13 February 2019

**RE: Northampton Gateway Rail Freight Interchange
Document 8.14, Hyde Farm House – Minor Scheme Amendment, Dated 8 January 2019
Planning Inspectorate Reference Number: TR050006-001045**

We refer to the subject document that was submitted by The Applicant as part of their Deadline 4 submission. We are writing to you as the Owners of Hyde Farm House and referred to in the document as the Landowner.

Submitted design - Extract From Document 2.4D - Rev P9 (with Hyde Farm house Highlighted)

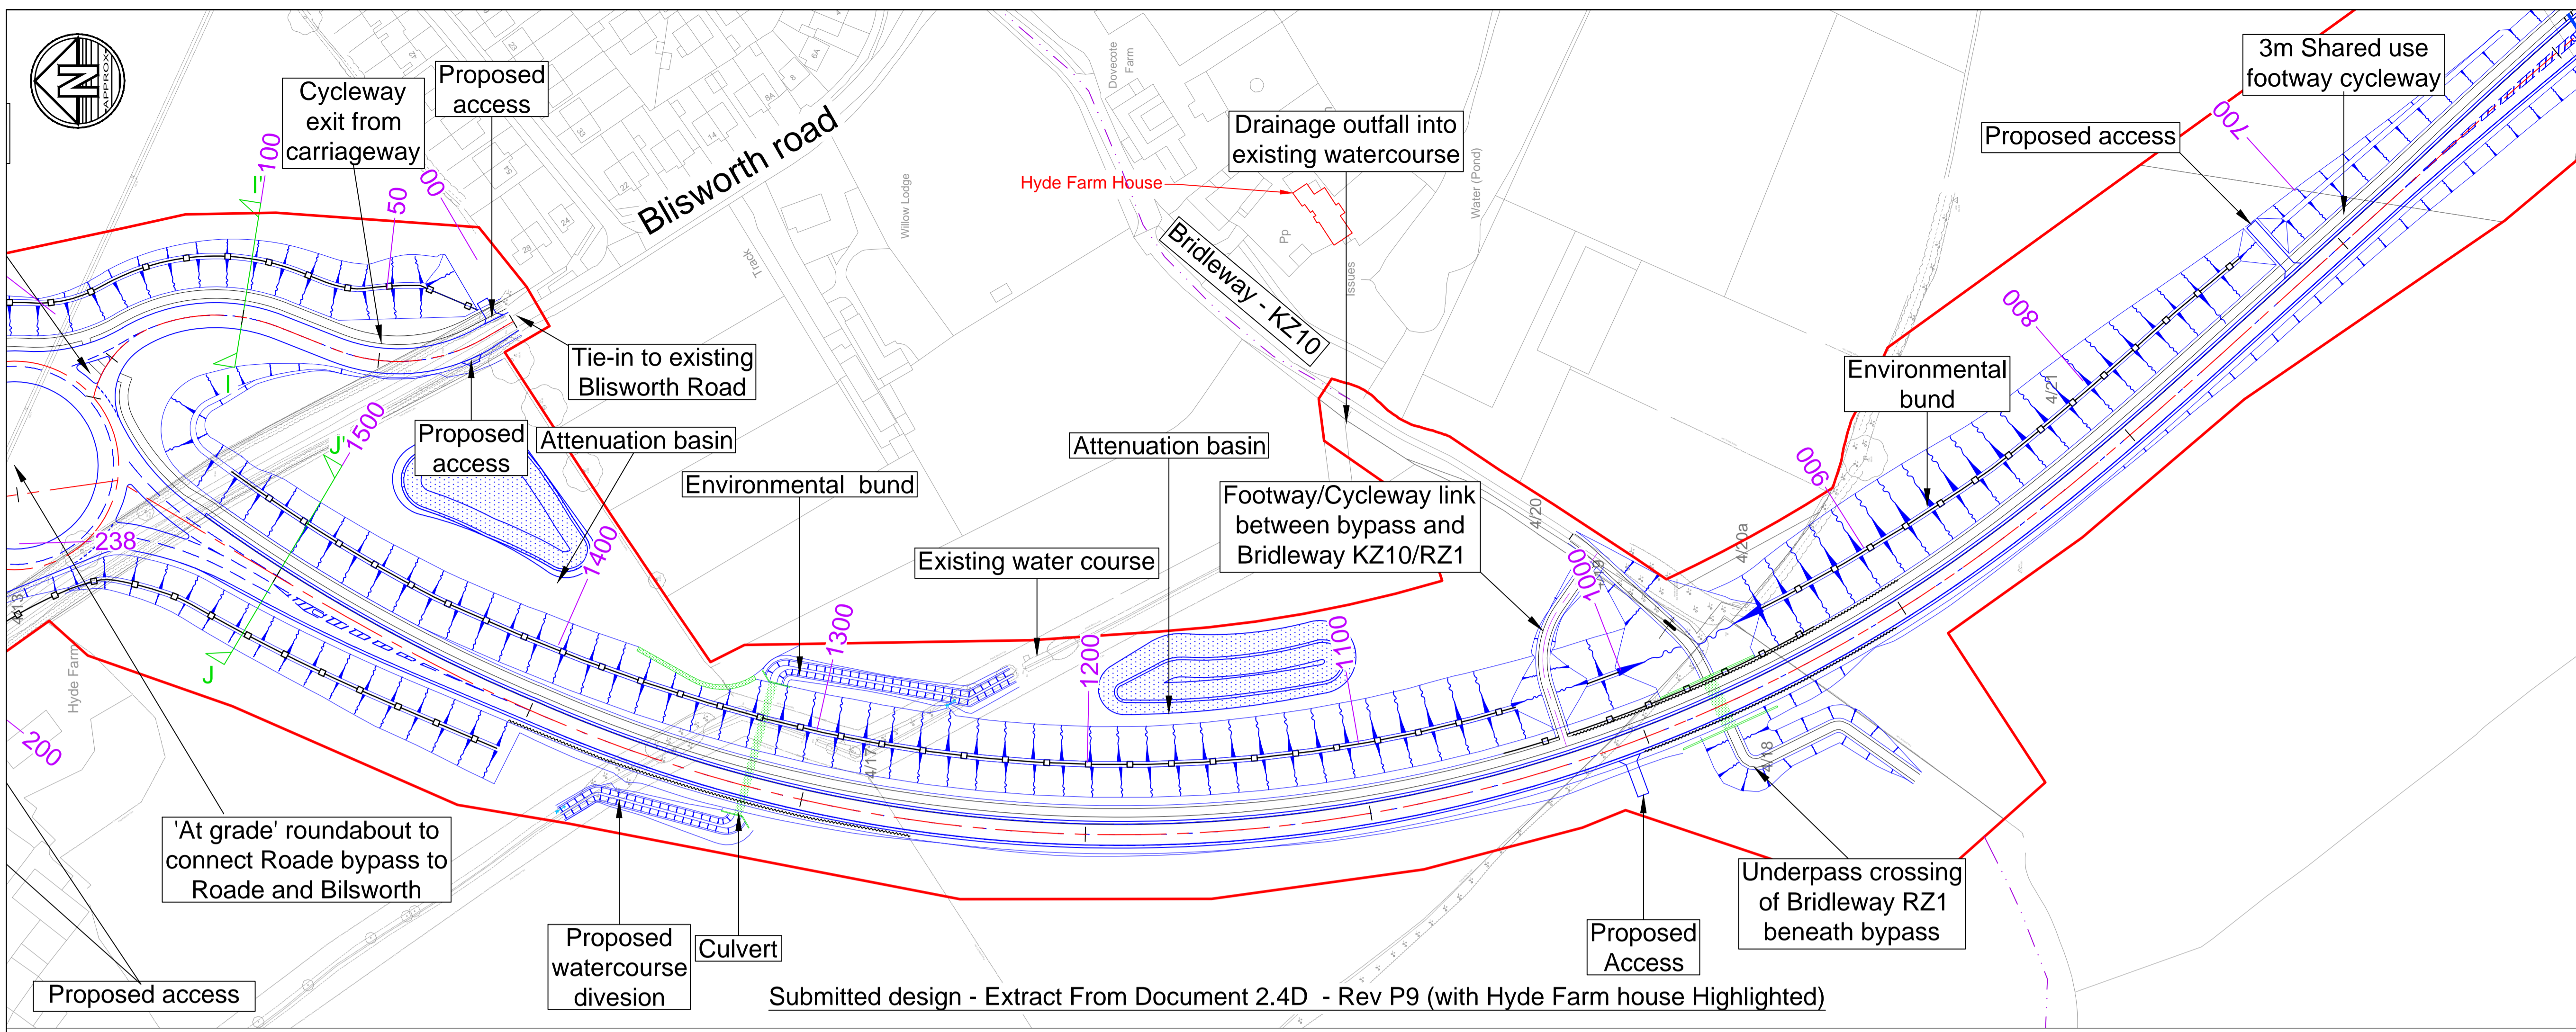
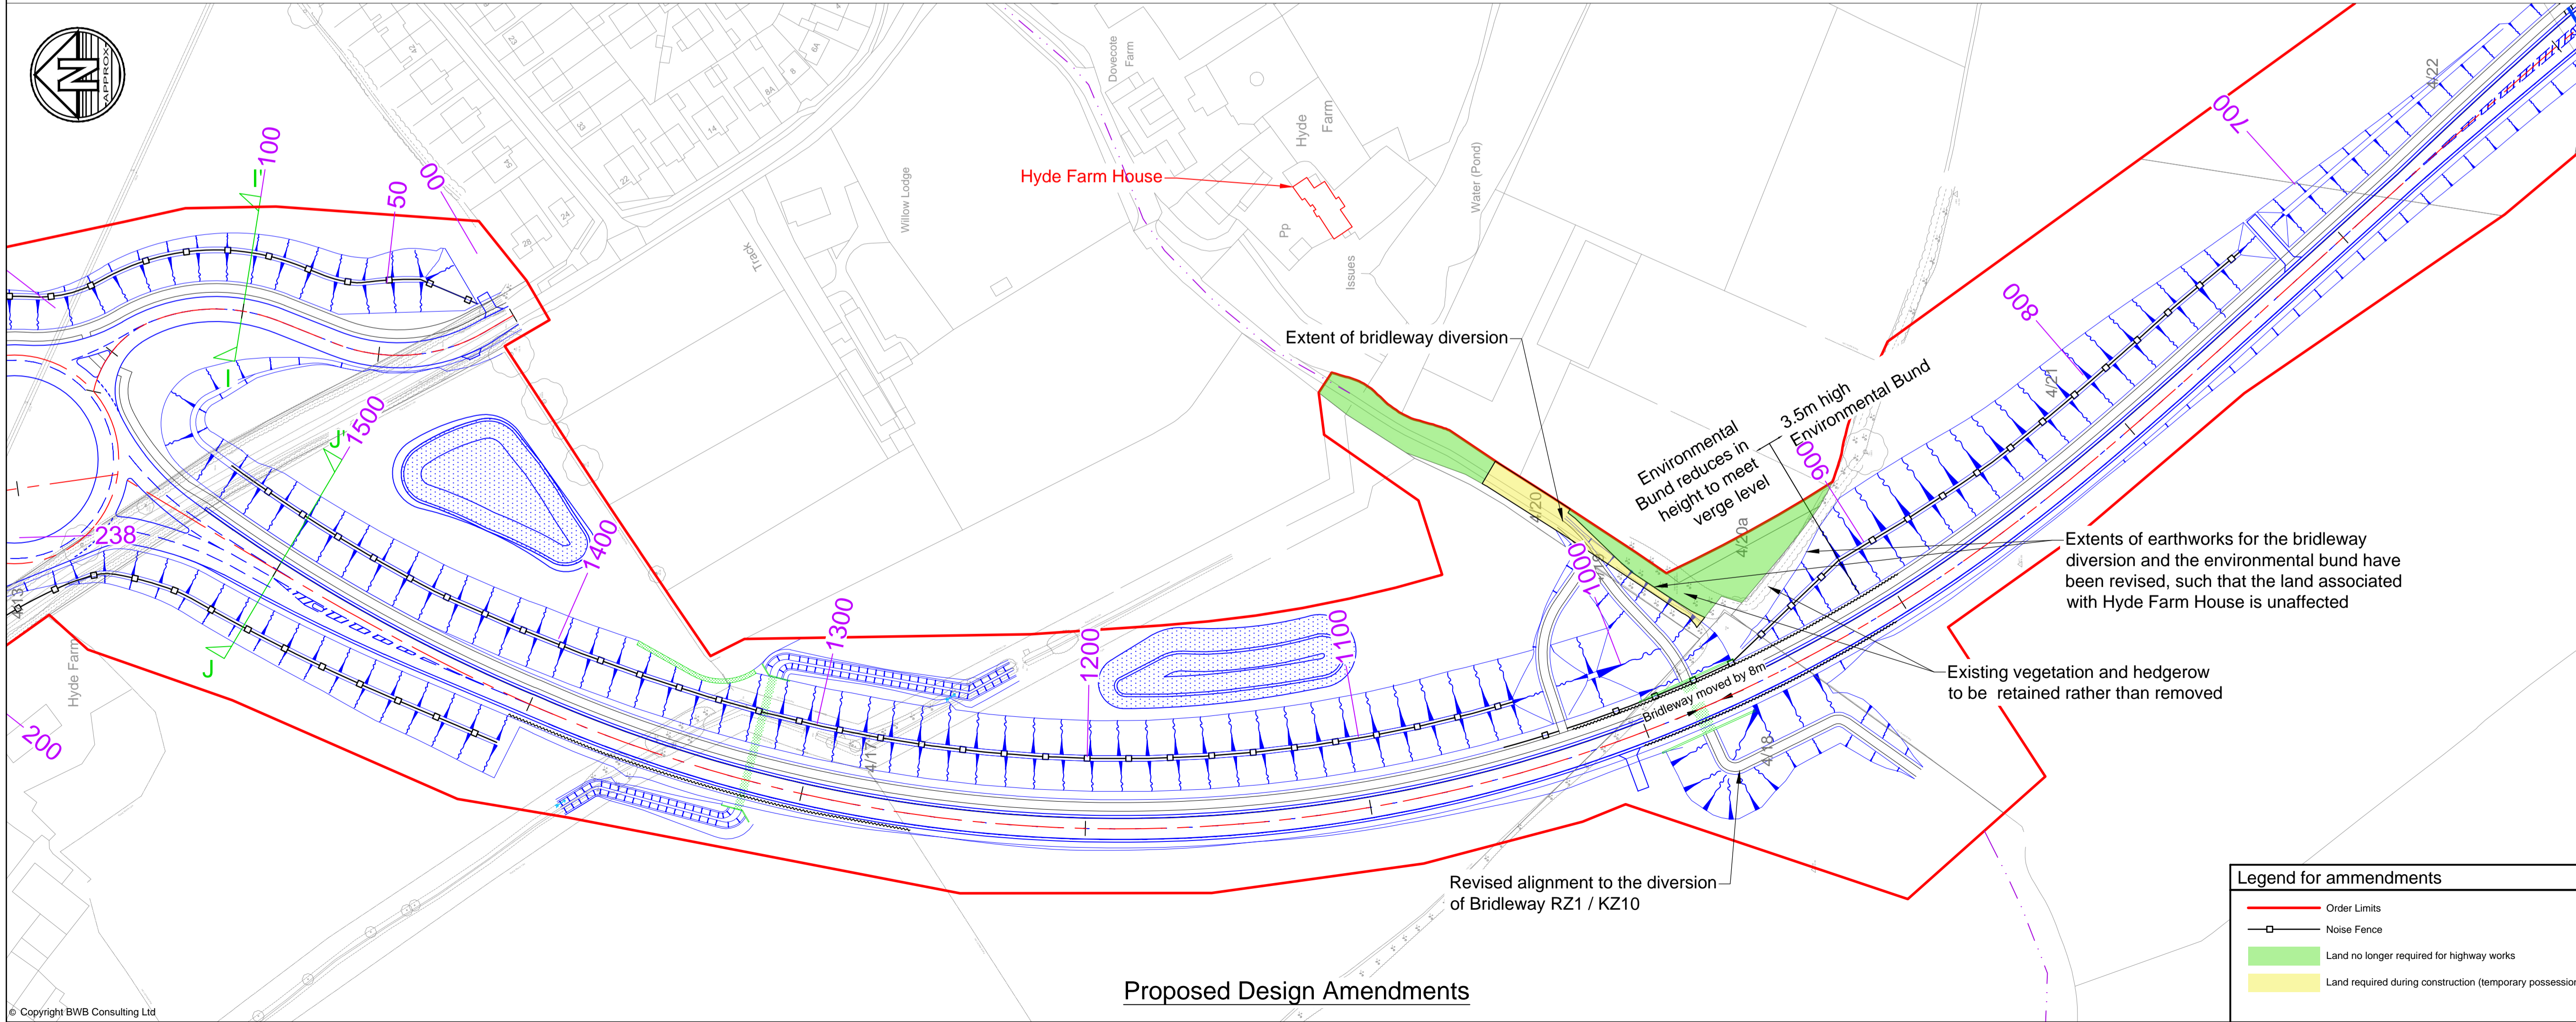
- iii. The of the volume of the bund adjacent to our property has been reduced and therefore the functionality of the bund in respect of screening and noise reduction has been diminished. We are at a loss to understand "how the impact has been reduced" and no explanation has been offered by The Applicant. By reducing the volume of the bund, as detailed in this design amendment, the impacts from the proposed bypass have been worsened.

- iv. Hyde Farm House is a Grade II Listed building and we wish to minimise any impacts that the proposed scheme will have on the property.
- v. Paragraph 4 also mentions the environmental impacts; we continue to have concerns regarding the discharge of water from the bypass into our “large pond” for which we have no information. The Applicant has not, thus far, been able to satisfy our concerns regarding the potential risks to us, e.g. water contamination etc. Furthermore, The Applicant does not have any agreement with us that they can use our “large pond” for drainage purposes.

We ask that as part of your recommendations to the Secretary of State, that you to place a “condition” that this design amendment is not approved and the original design is re-instated, should the scheme be approved. The reason for this is to minimise the impacts of the scheme on our property.
